**From:** Gregg, Robert <Robert.Gregg@lancashire.gov.uk>  
**Sent:** 07 September 2018 12:03  
**To:** Stephen Kilmartin  
**Cc:** planning  
**Subject:** APP. 3/2018/0696 - CALDING BANK COTTAGE, BILLINGTON

After having light shed on the status of the application which would be for the proposal of a new residential dwelling as opposed to a 'guesthouse'. Along with receiving the revised parking arrangements, It would appear that the proposal would generate further vehicle movements which in turn would bring my attention to the access road which would approach the new residential dwelling from the highway.

Project					
Calder Bank Cottage, Whalley Old Road, BB7 0JE					
Drawing Title					
Proposed Site Plan					
Drawn	Checked	Paper Size	Scale	Date	
PL	PL	A3	1:200 @ A3	JULY 2018	
Project No.		Drawing No.		Revision	
18 - 262		005		E

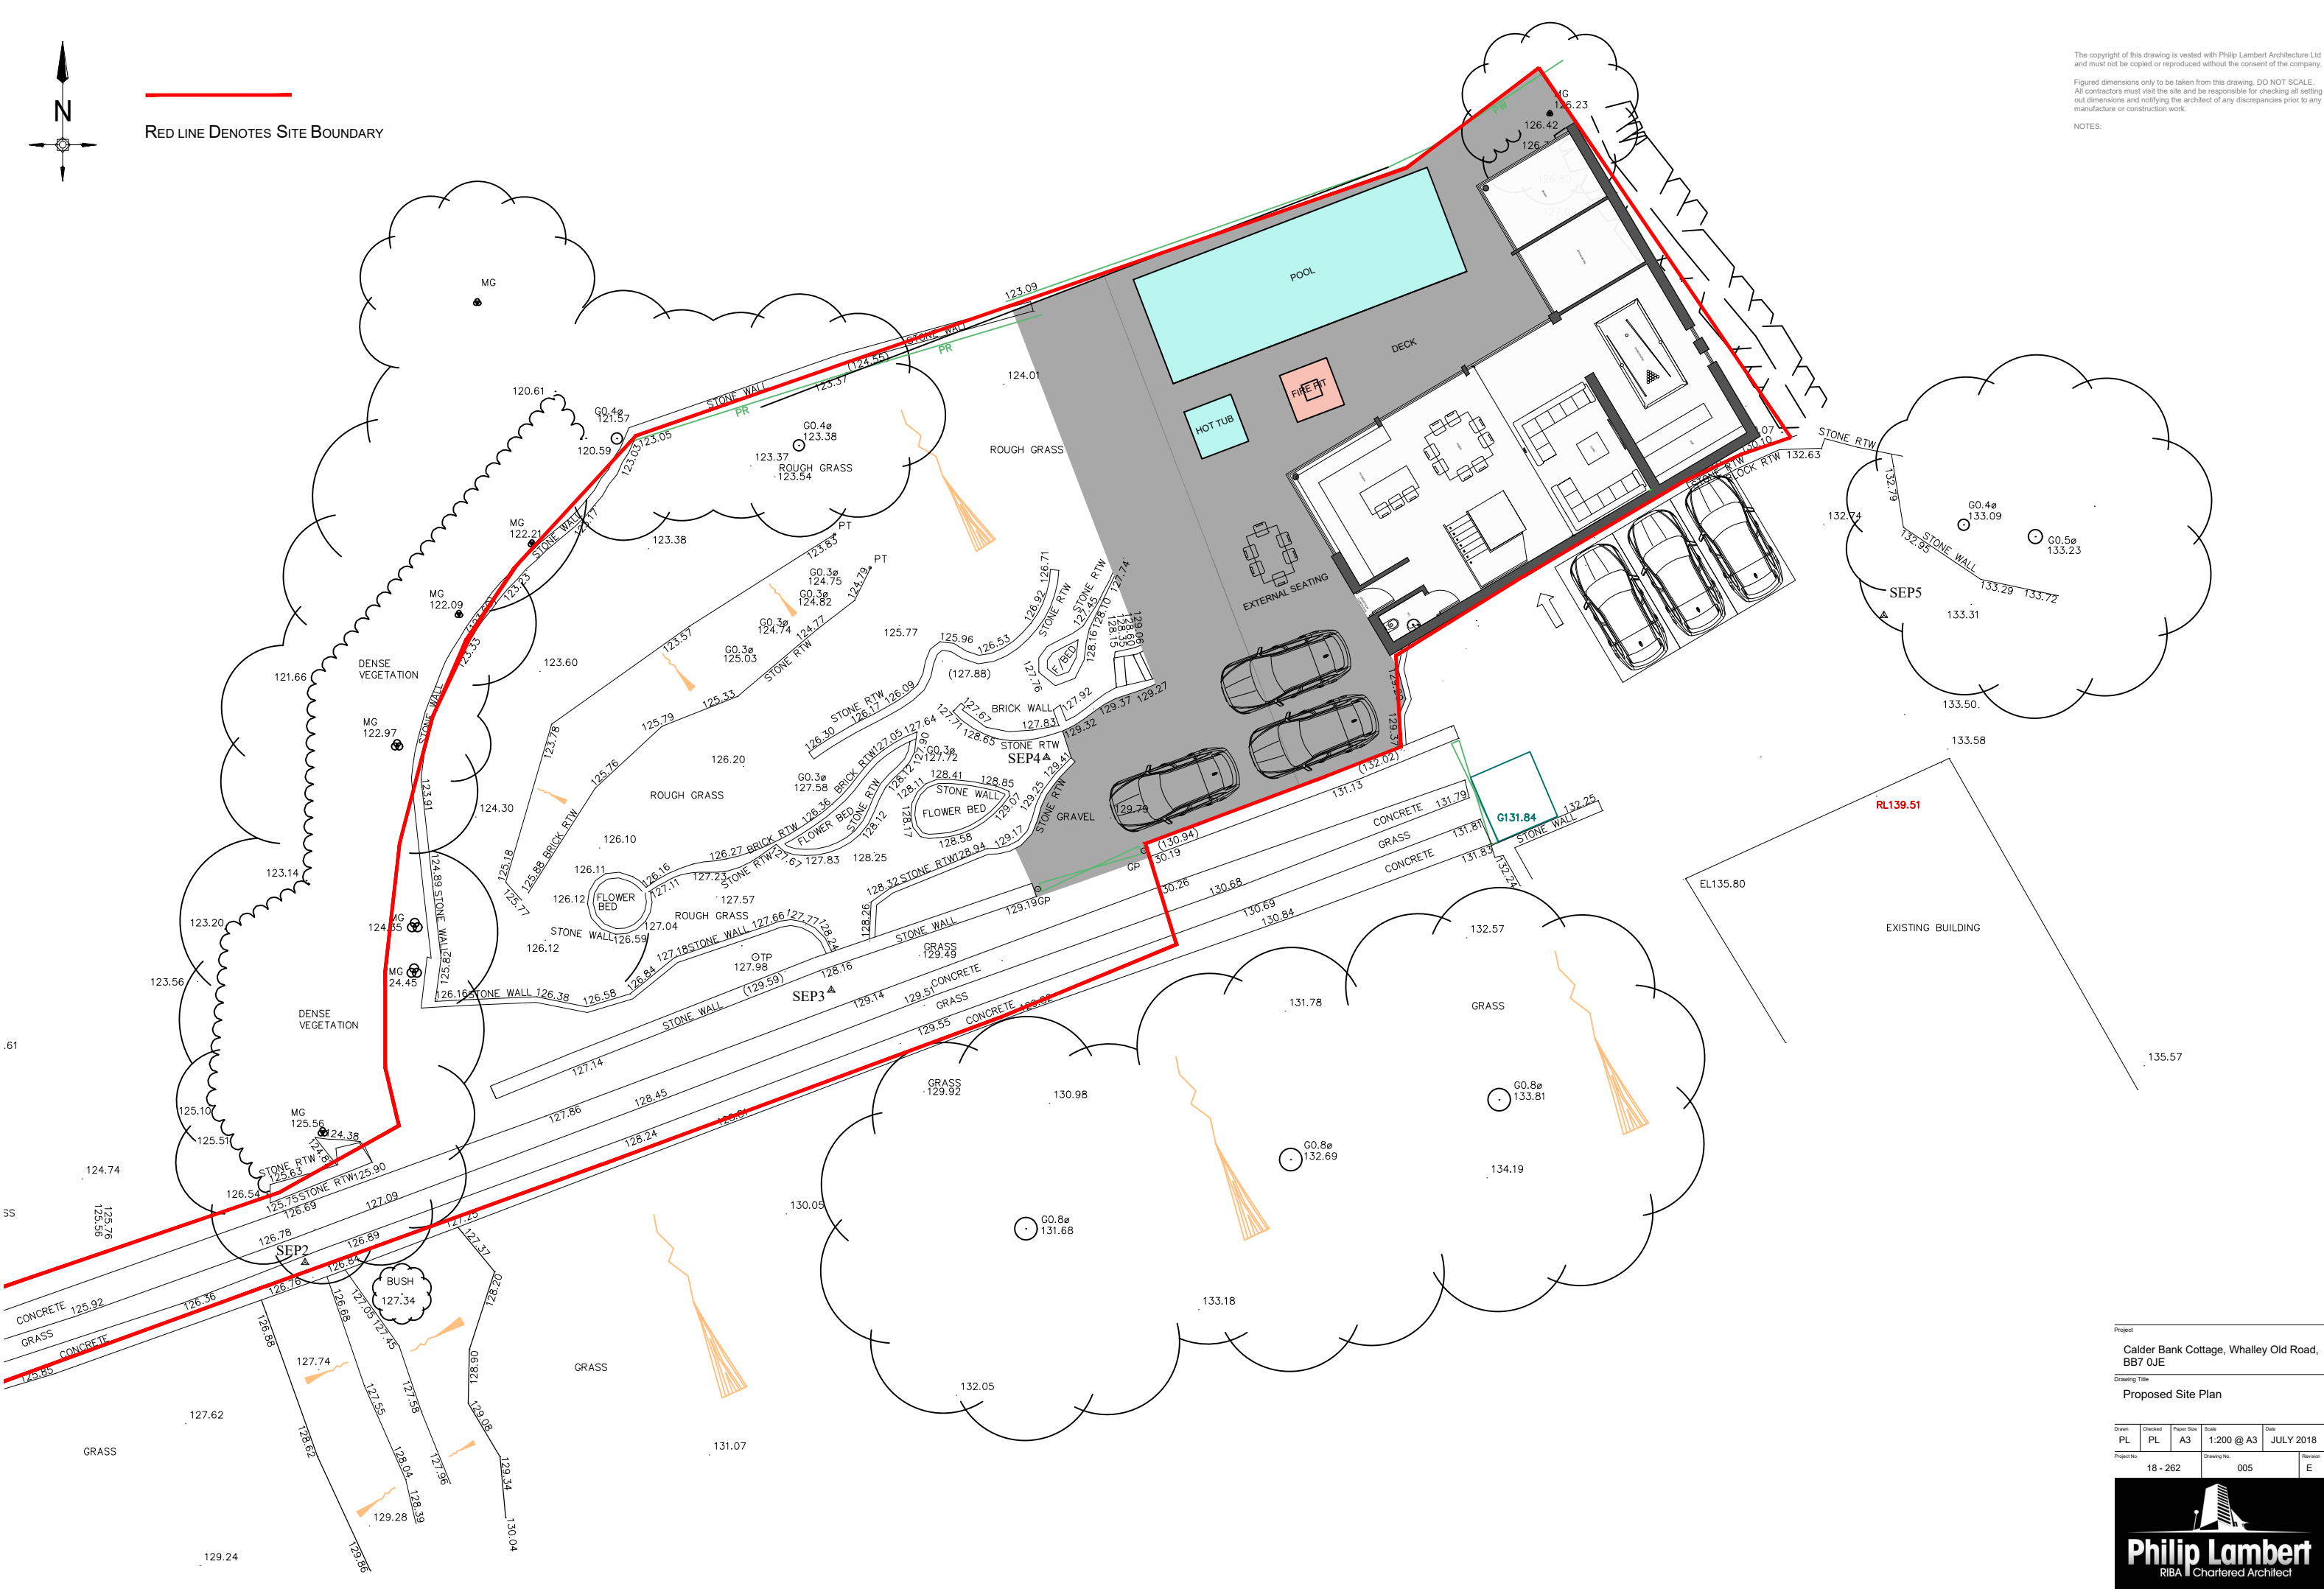
The private road is approximately 150 meters long from the highway to the proposed new dwelling and is currently of a substandard structure and formation. In order to withstand the increased generation of traffic flow, The road would need to be brought up to standard. I would fully expect to see a passing place along the road while also the access point would need to be widened to allow the passing of 2 vehicles at the entrance so that no vehicles at any point would have to wait in the highway in order to enter the access point.

The new construction of the access road shall be fully hardstanding all the way from the entrance right up to the top of the access road to meet with the existing hardstanding/tarmacadam area.

I would ask that the plans be revised detailing the above.
